Consultation Response from: KC Environmental Health (Pollution & Noise Control)
2025/92443 - Huddersfield Open Market, Brook Street, Huddersfield, HD1 1DY

External works to Market Building and wider site including alteration and demolition of modern additions to the Market building, new glazed screens, new WC and welfare facilities, provision of services and lighting including associated works, remodelling to the stone annexe, alterations to catering facilities, and self-contained commercial units, works to floor surfaces of Market Building. Use of Market Building for a mix of uses (sui generis) including retail, hot food takeaway, drinking establishment, restaurant / café uses, market office, public welfare facilities, storage facilities as well as provision of areas that provide a mix of fixed and flexible indoor and outdoor market stalls. Creation of areas for open market, siting of associated structures, installation of new fixed market stalls demolition of external bin store and creation of waste compound area, storage compounds, vehicular parking, remodelling and surfacing of areas of hardstanding, street furniture, car park layout, installation of parcel lockers, landscapin

Figure 4: Sound contours at 3 m, showing the night time calculated specific plant sound level,  $L_{Aeq 15 \text{ min}}$  (with mitigation)

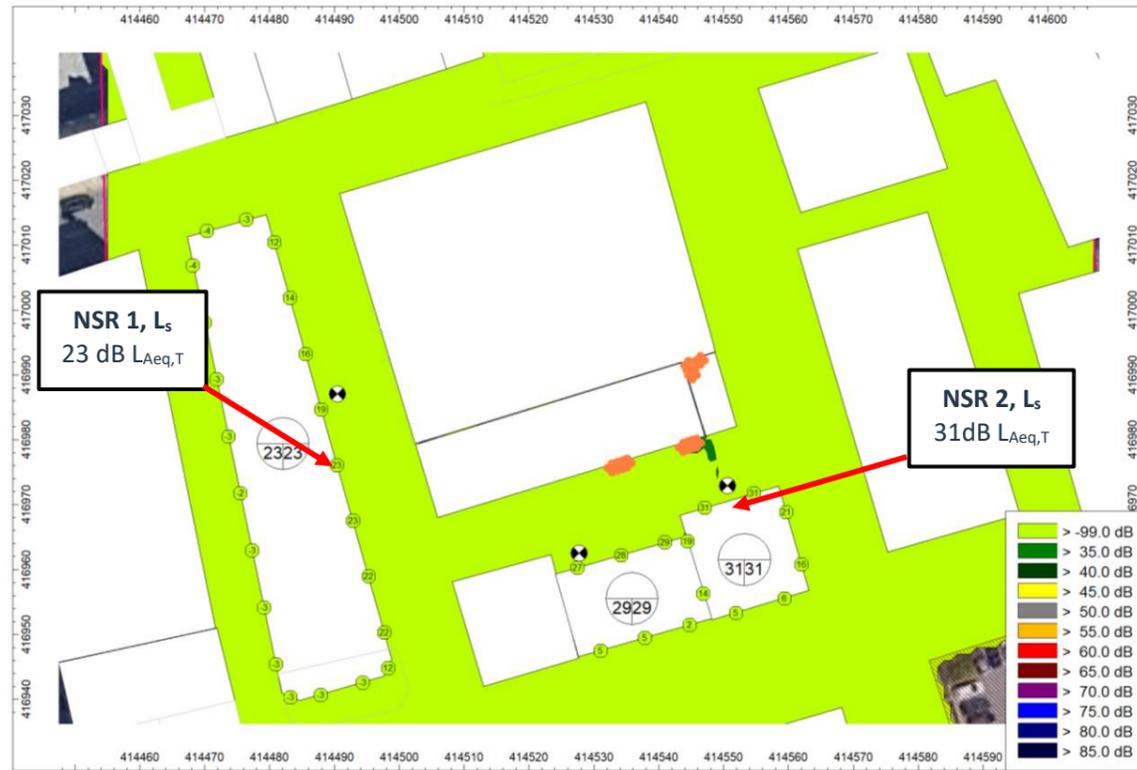
In our comments dated 01 October 2025, we asked for clarification on the modelling being conducted with all doors being kept closed but this has not been received and the Planning Officer is advised to accept this if it is confirmed. We also asked about the impact the access/egress restrictions would have on the identified NSR at Brook Street. A Noise Impact Assessment authored by Apex Acoustics dated 21 August Ref 12671.1001 RevC has been submitted and figure 4 shows this NSR with table 12 estimating a low impact to them. This is accepted.
